Spring Brook Wind Turbine Proposal

Woodward , Matthew (Planning) <MatthewWoodward@barnsley.gov.uk>

Thank you for your e-mail and your Screening Request dated 27th July 2012. In response, I attach a copy of the Council's Screening Opinion.

Wireline View - REPower MM82 - 82m Diameter, 60m Hub, 101m Tip

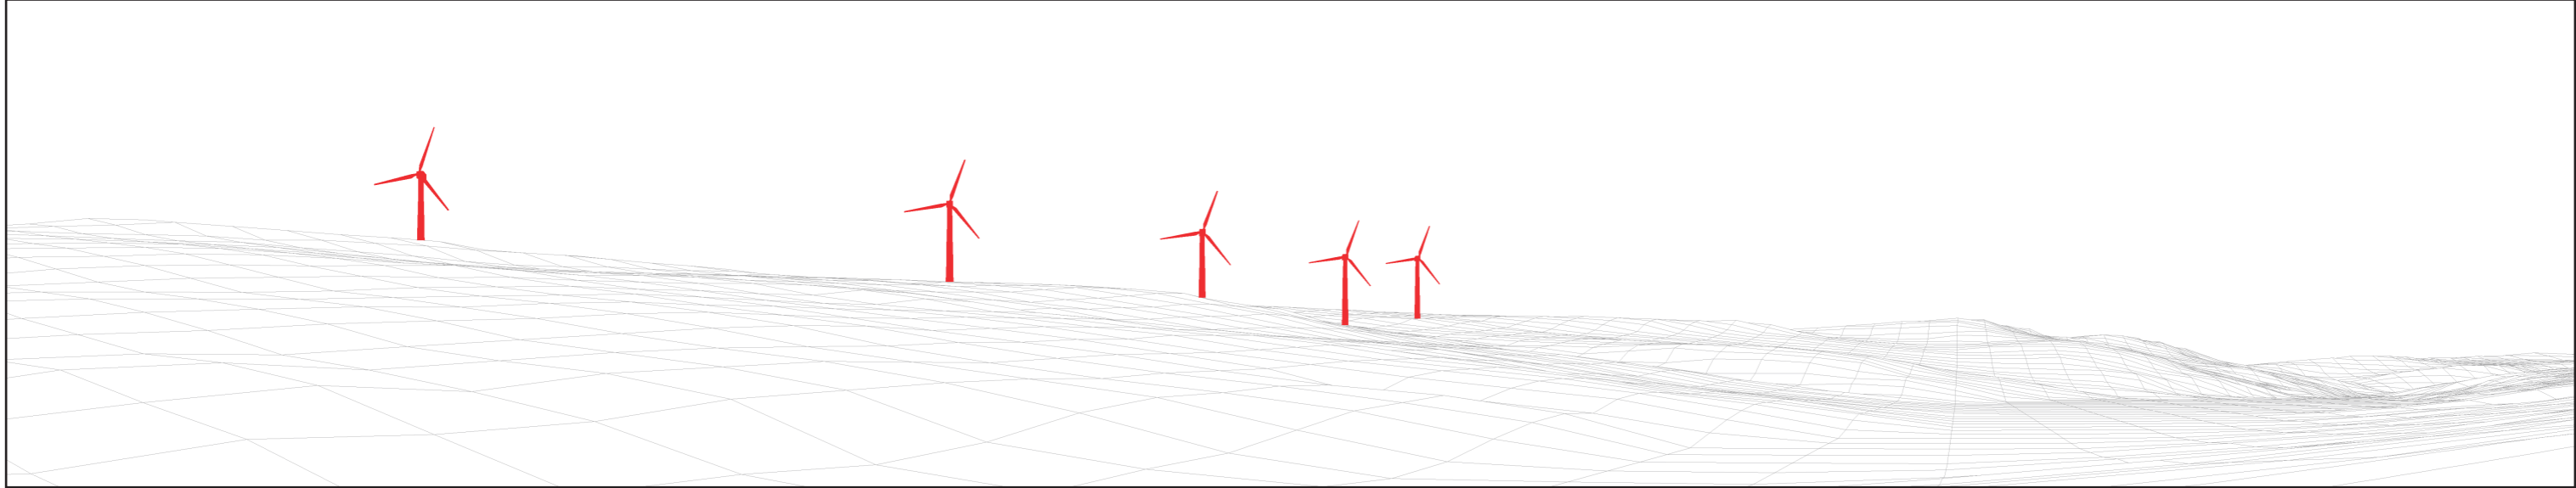
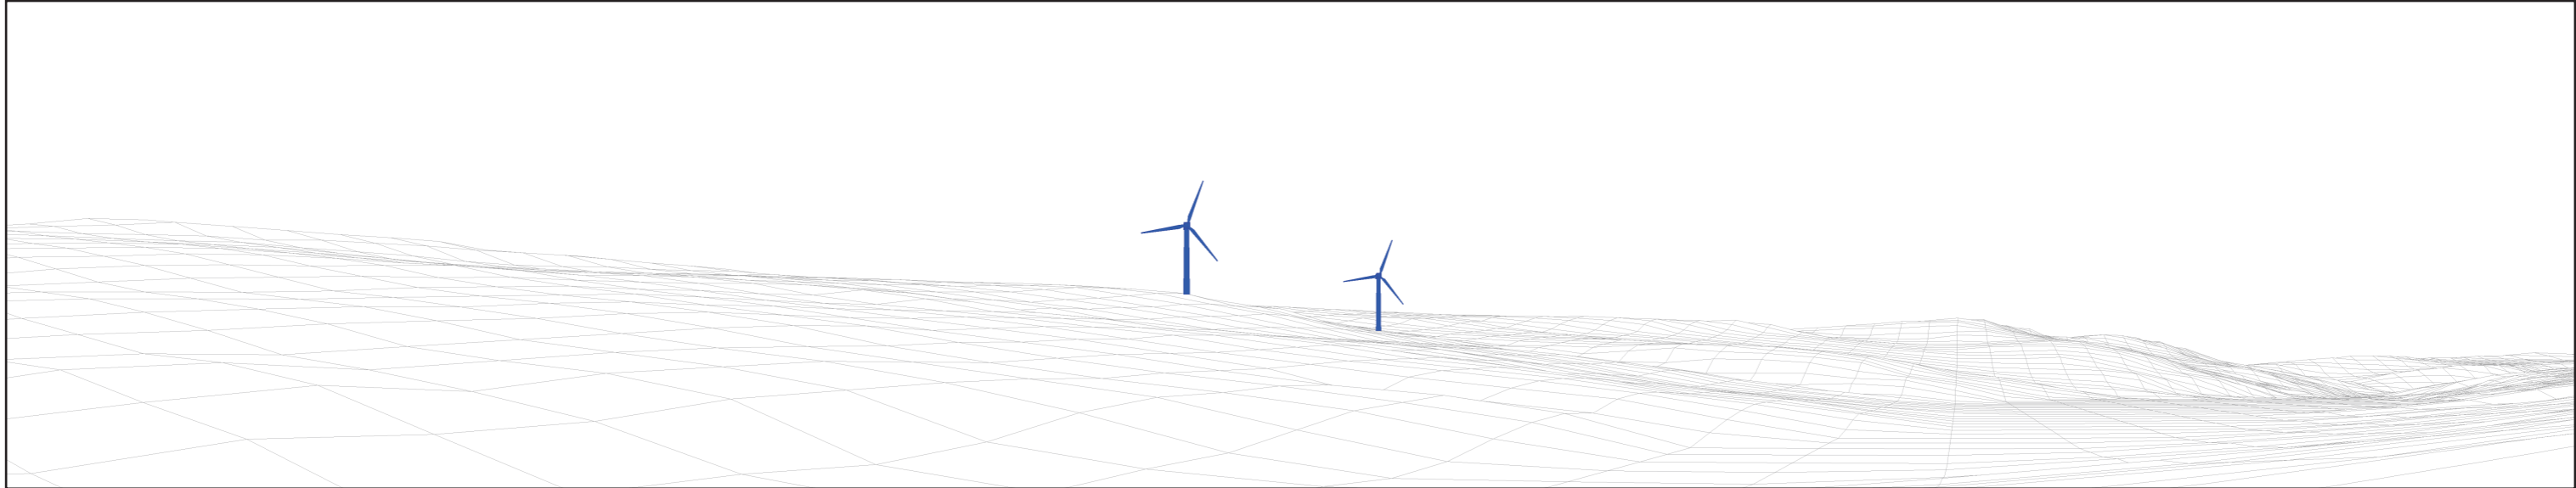
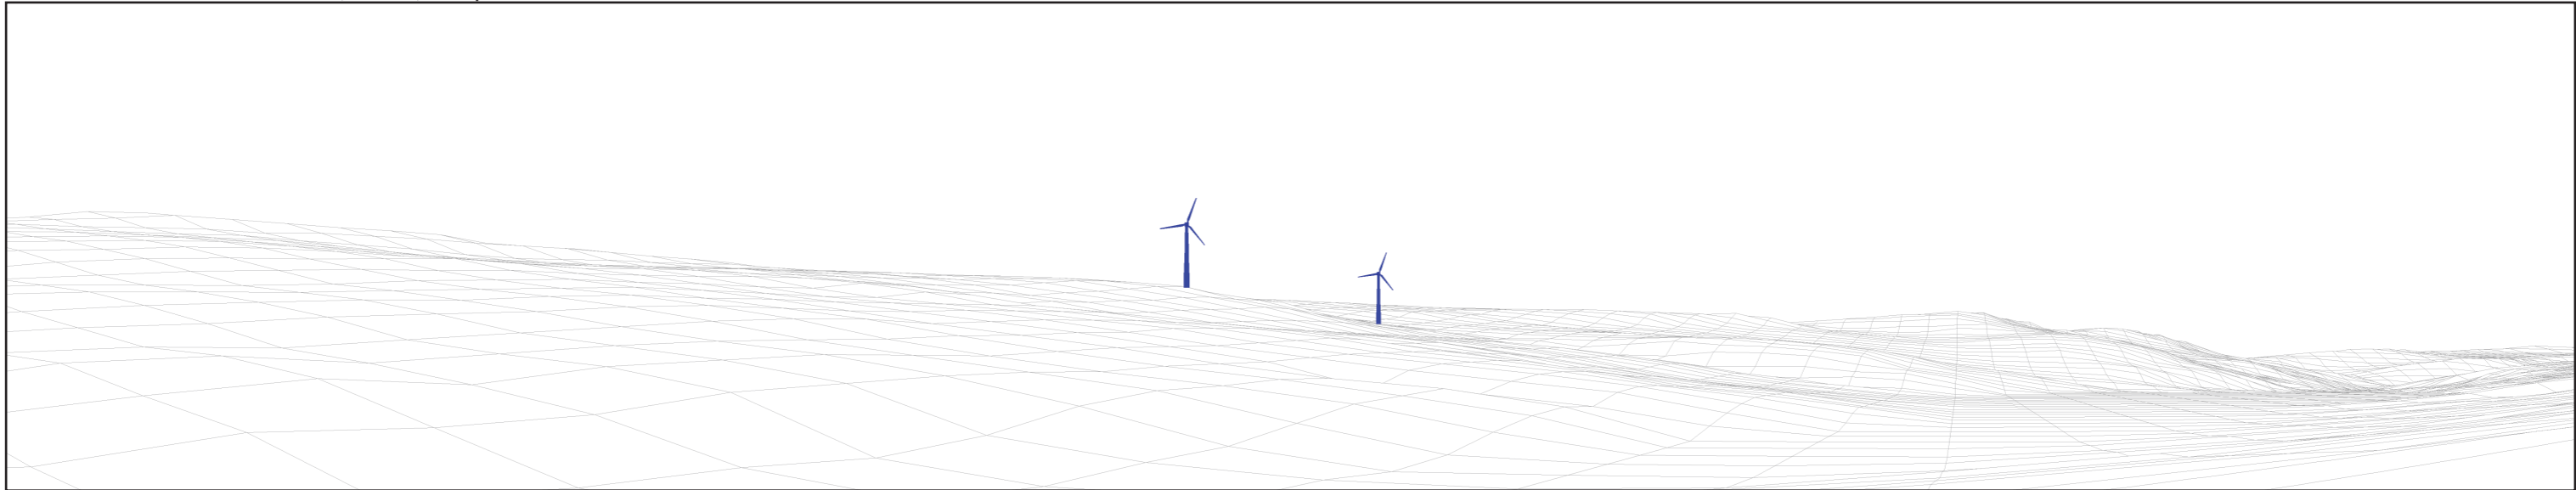
The smaller turbines (79m to tip) appear (based on the submitted wire lines) substantially less obtrusive and visually prominent than the larger turbines. However, as you will be aware, this is a very sensitive site in so far as it comprises a steep sloping hillside which has a delicate appearance and in my opinion, the character of the area could be compromised by a scheme which appeared out of proportion with its surroundings. In particular, concerns were previously expressed with the scheme (2008/0838) when viewed from Midhopstones Conservation Area and the Peak District National Park. Therefore, in any new submission you would need to demonstrate that there was no significant harm to the Peak District National Park or the local heritage assets and demonstrate that landscape and visual impacts were acceptable. In addition you would need to demonstrate very special circumstances which clearly outweighed visual harm given that the site lies within the Green Belt.

Finally, I should point out that the advice contained in this e-mail is provided based on the very limited information submitted in the form of selected wire-lines and photomontages. As such, the advice is given without prejudice. I would expect any new submission to include photomontages taken from similar locations to those submitted with planning application 2008/0838. However, should you be in agreement, I will provide you with a scoping opinion within 5 weeks of the date of this e-mail.
